Recommendation Report for Lawful Development Certificate for a Proposed Use or Development

REF NO: EP/124/21/CLP

LOCATION: 11 Warren Crescent
East Preston
BN16 1BH

PROPOSAL: Lawful development certificate for a proposed loft conversion.

Drawing Number 2021/198 Sheet 1 of 1

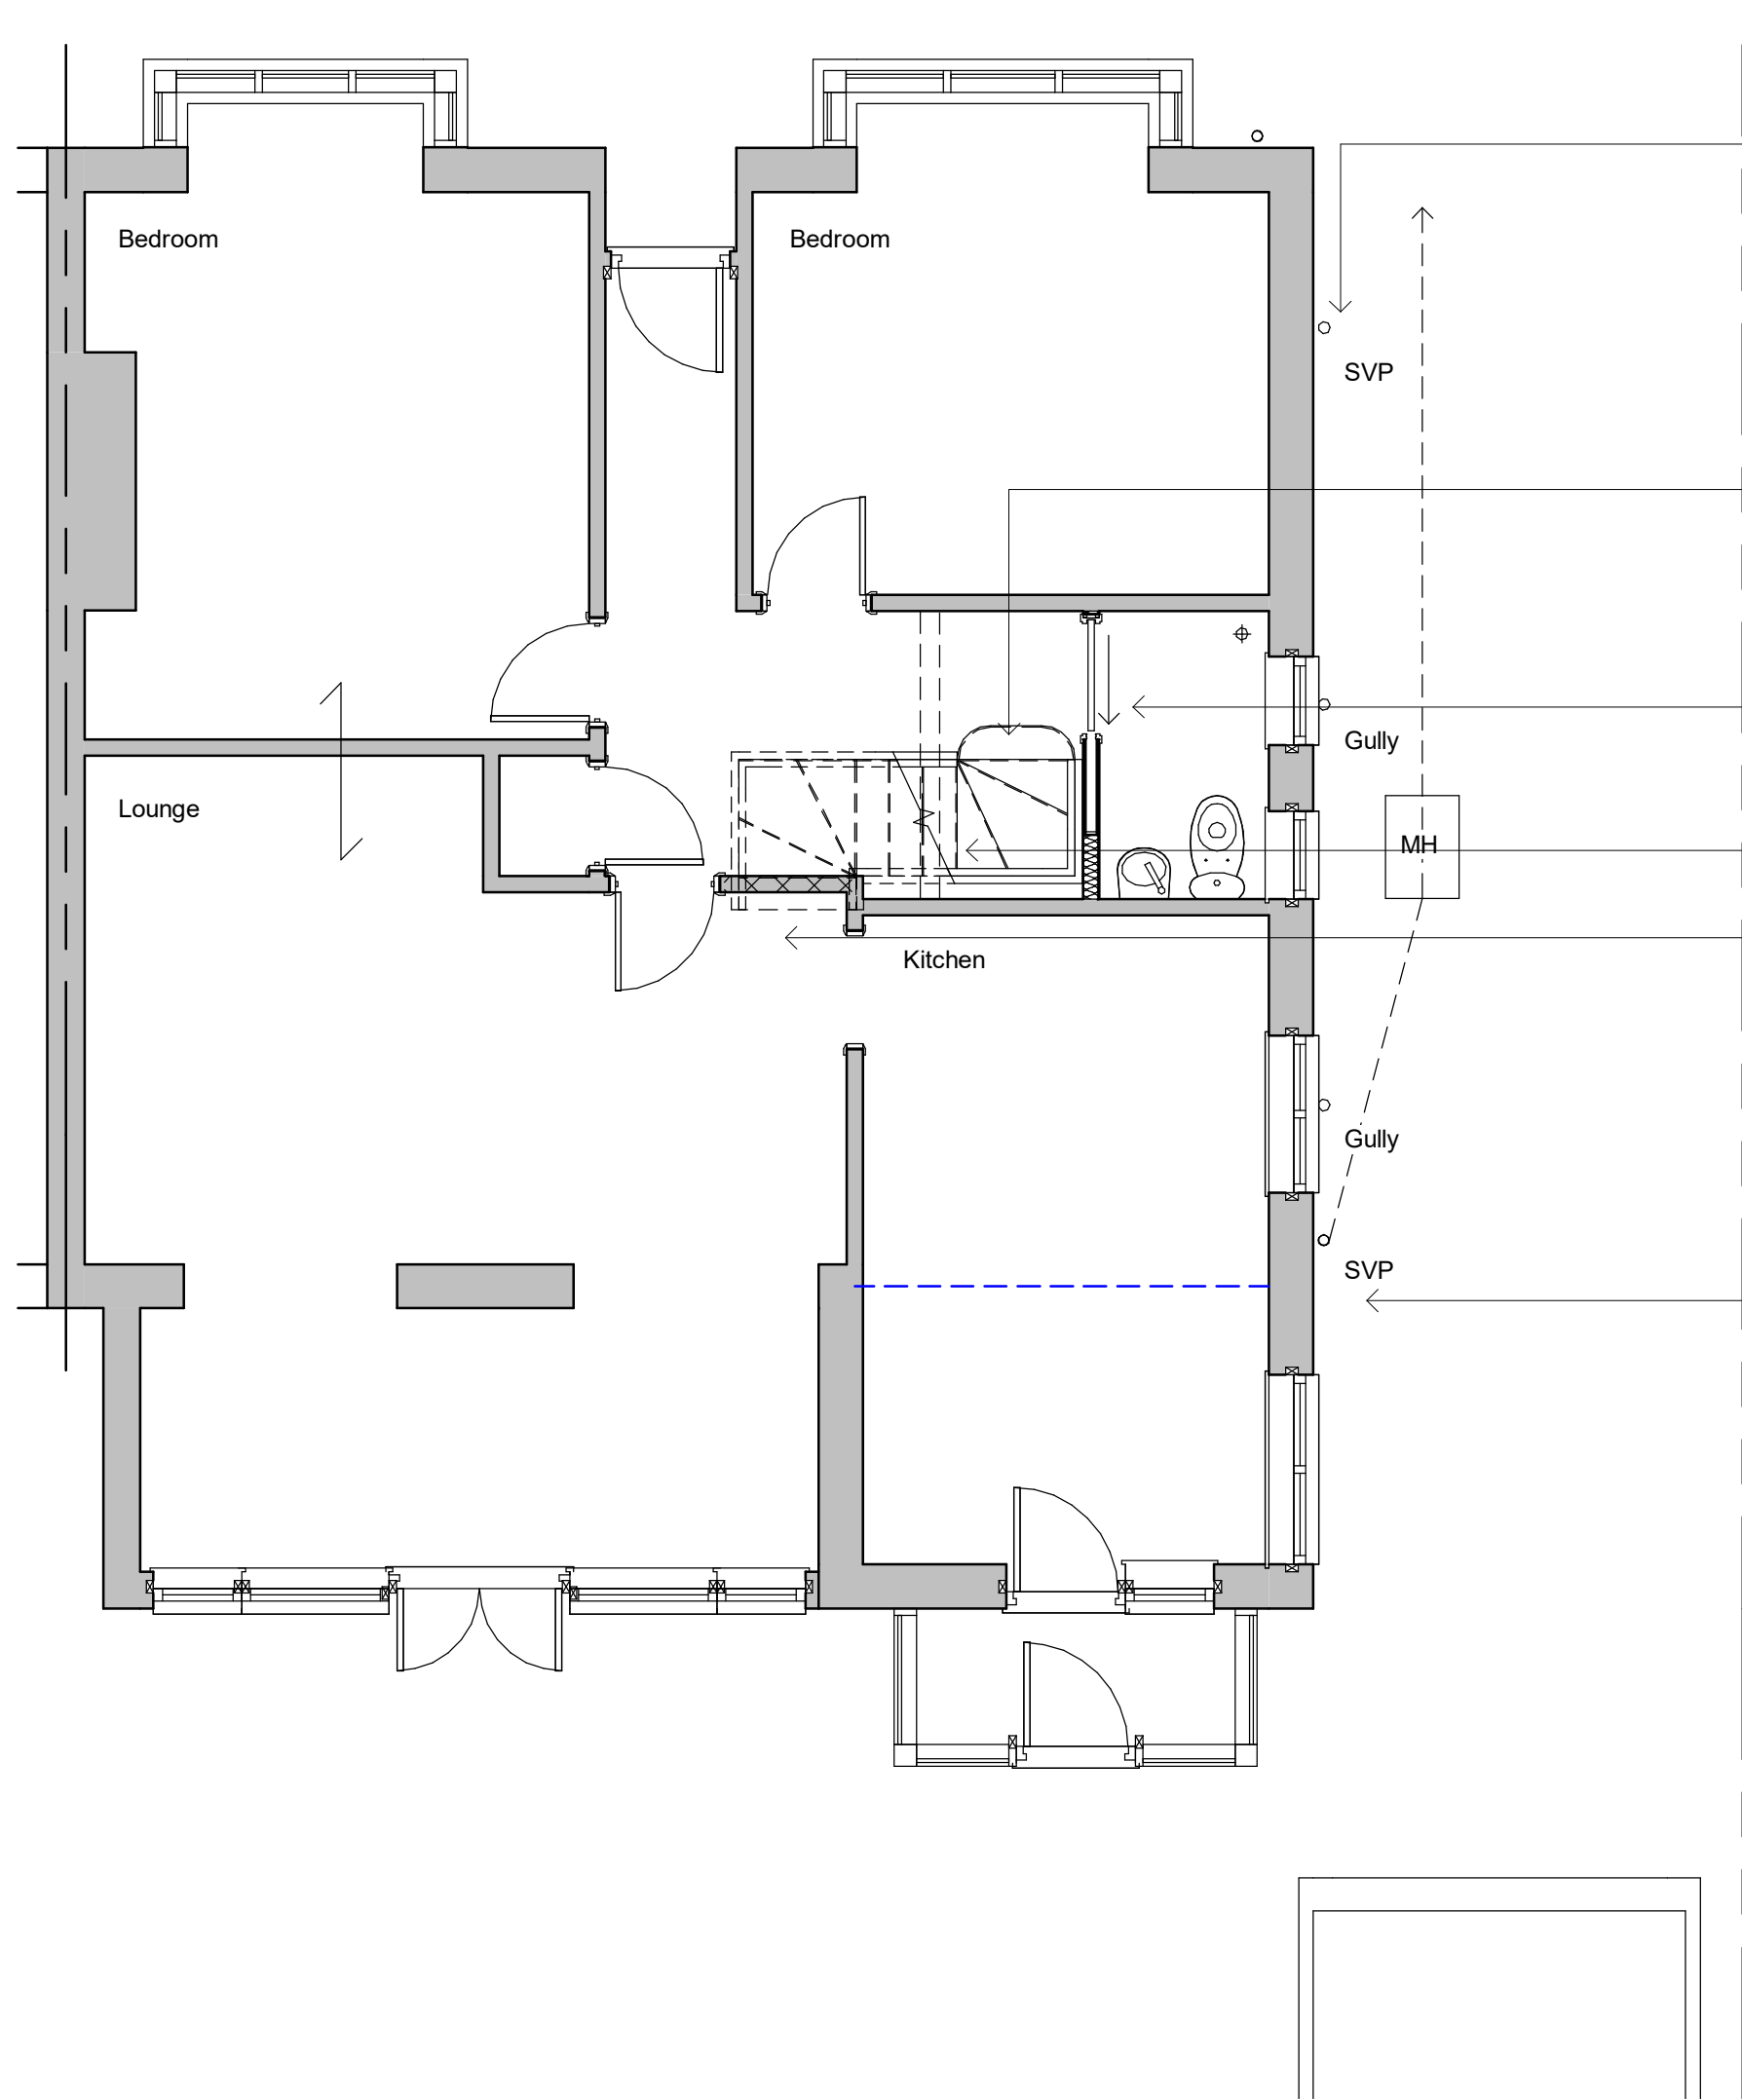
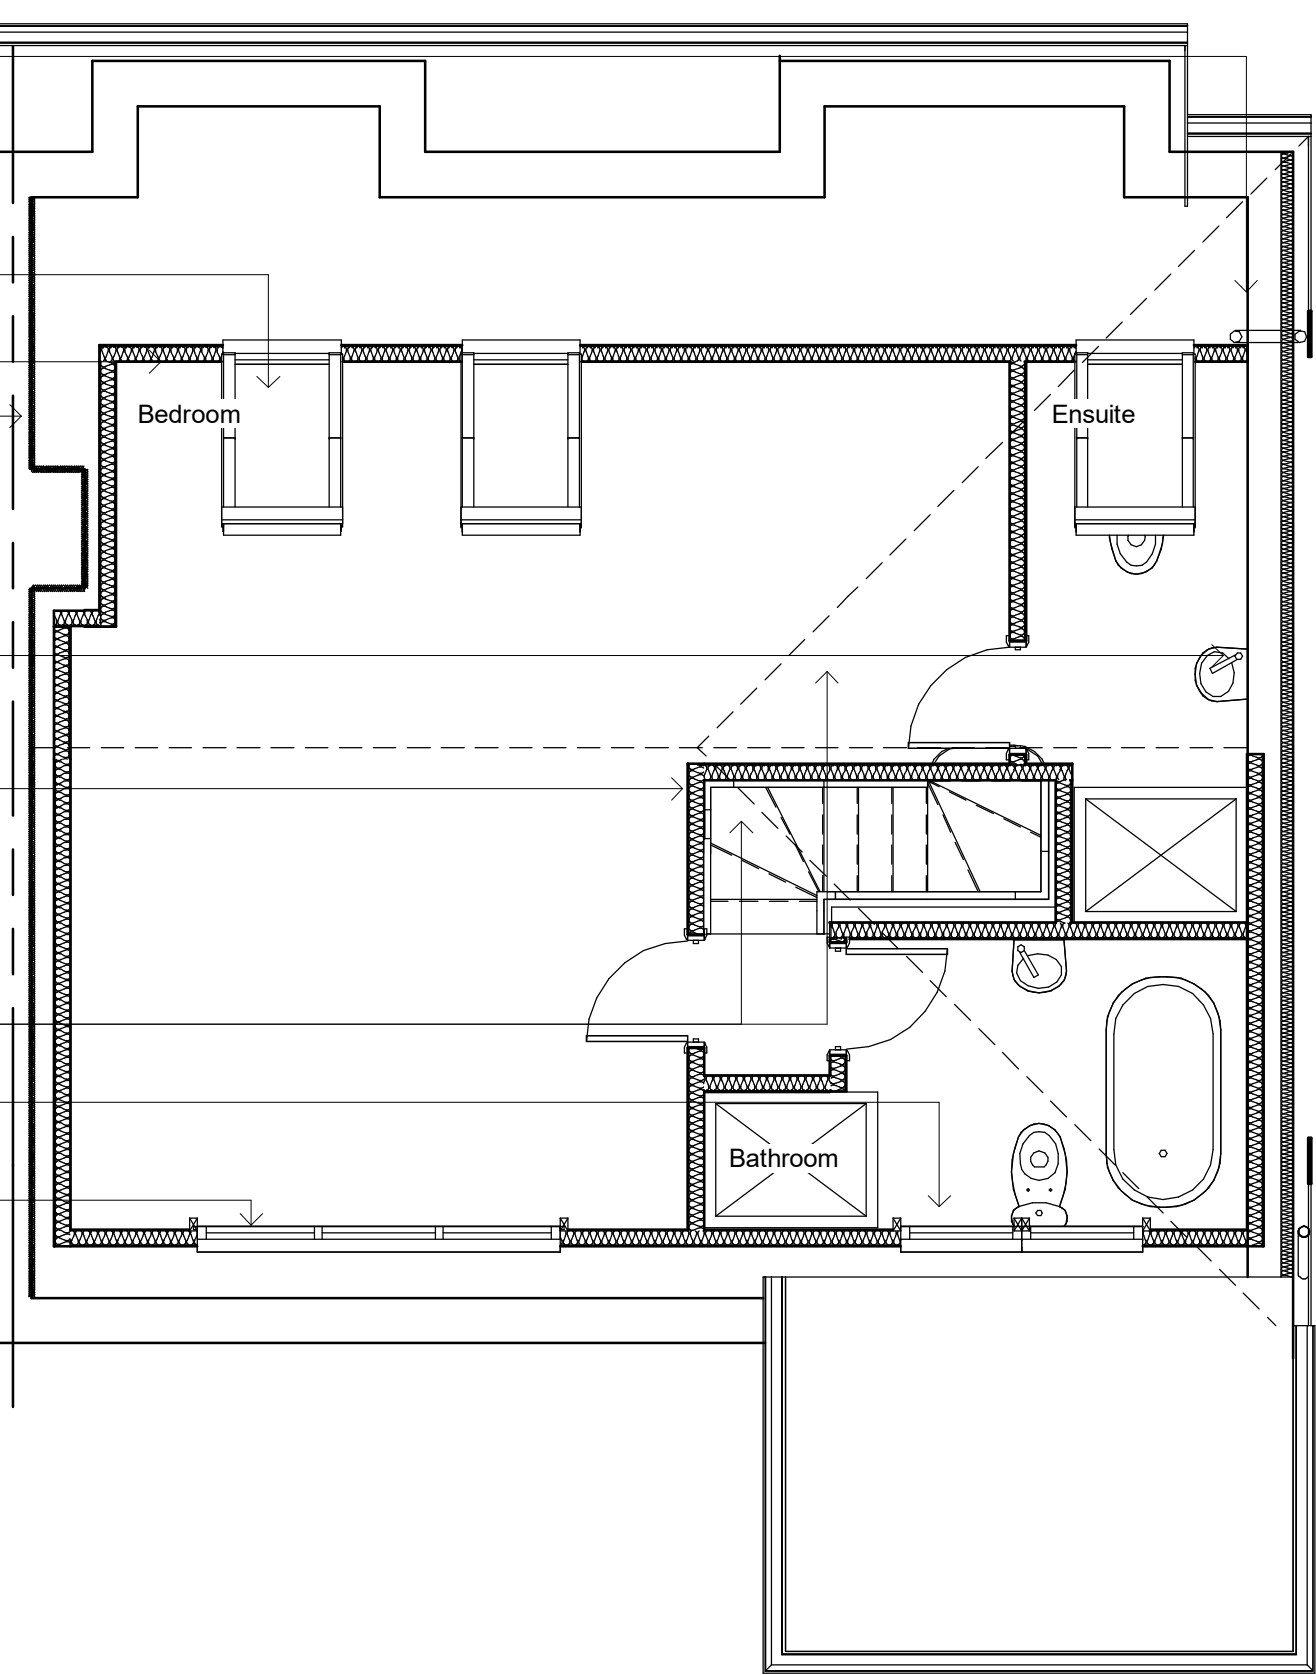
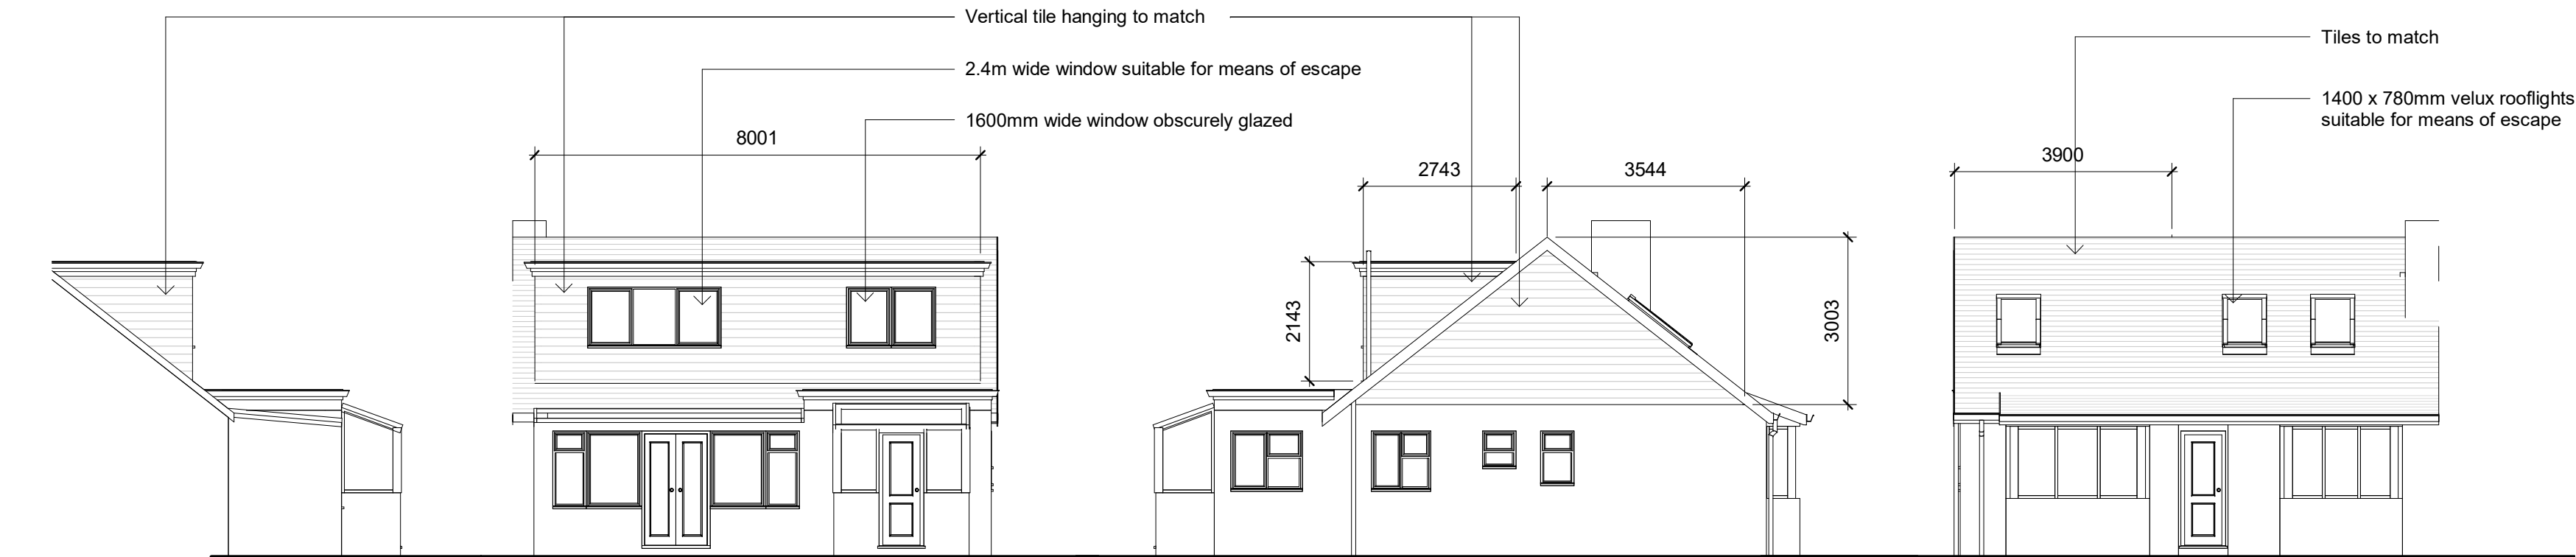
The property known as 11 Warren Crescent is a semi-detached property and is not listed or within a conservation area. The proposed extension would be of materials to match that of the existing.

The proposed loft conversion complies with relevant sections:

- B.1(b)(c)(dii)
- B.2(a)(aa)(bb)(ii)
- C.1(b)(c)

It is considered permitted development and as such does not require the submission of an application for full planning permission.
